Non-material Amendment to DC/21/05938

Proposed Conversion of Agricultural Barn to a Single Dwelling Fasbourn Farm, Buxhall

for Mr A Cornish

Floor Plan

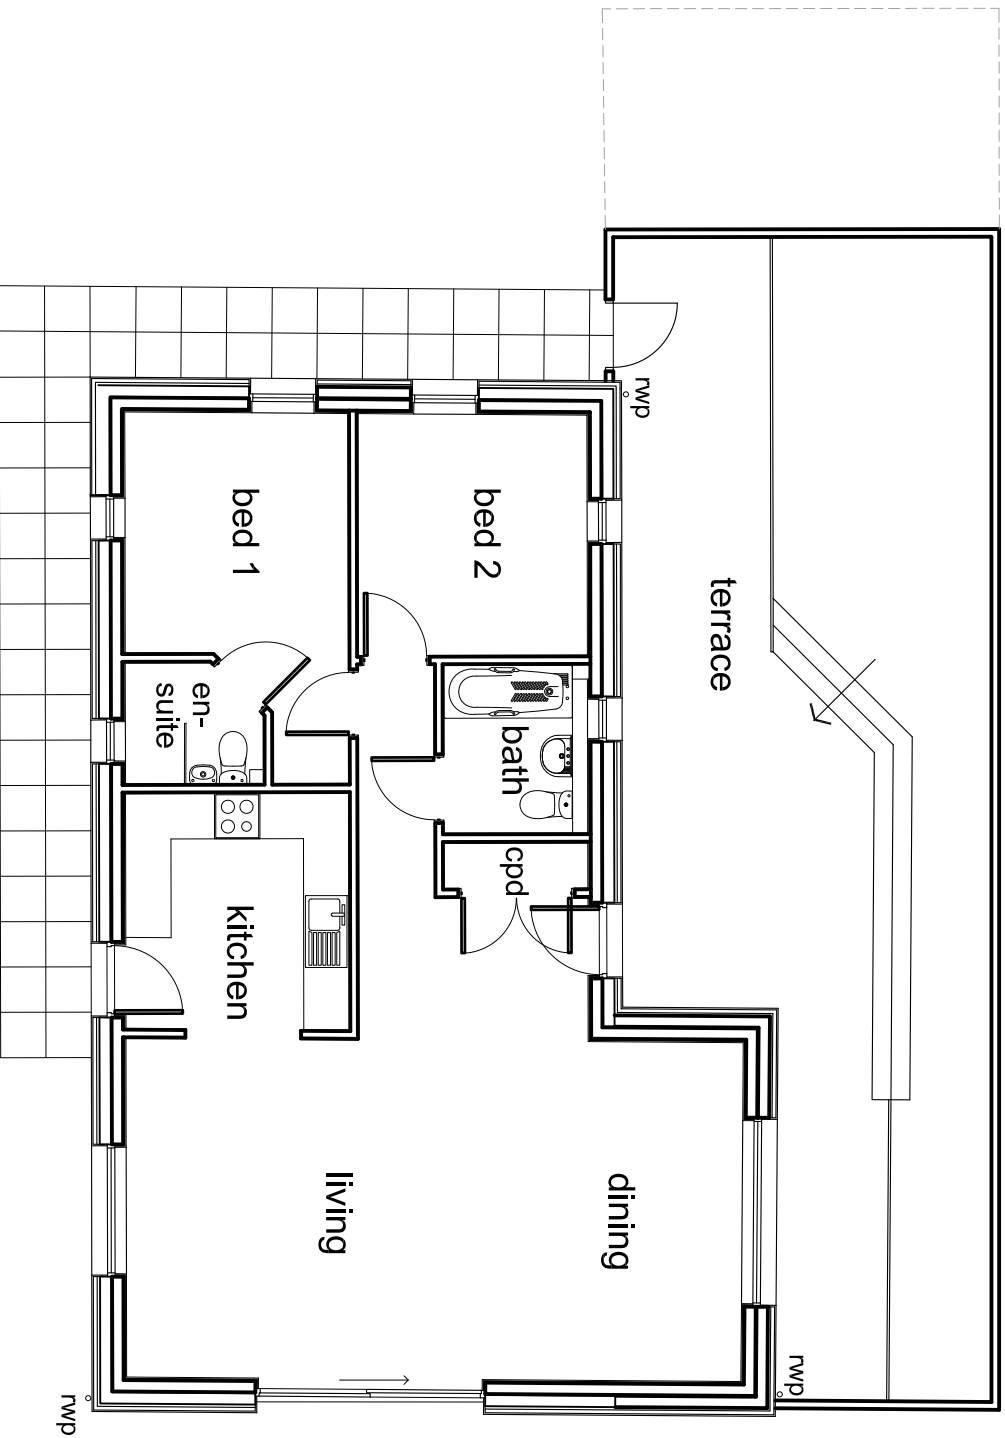
The internal layout has been revised as part of the design development with the Client / occupier of the proposed dwelling.

- Internal layout revised positioning the master bedroom and kitchen to the more southerly aspect
- Windows on the south-west amended to enhance views of the countryside.
- Removal of two large, glazed doors to north-west elevation; new smaller glazed door for increased privacy.
- Amended terrace / courtyard layout.
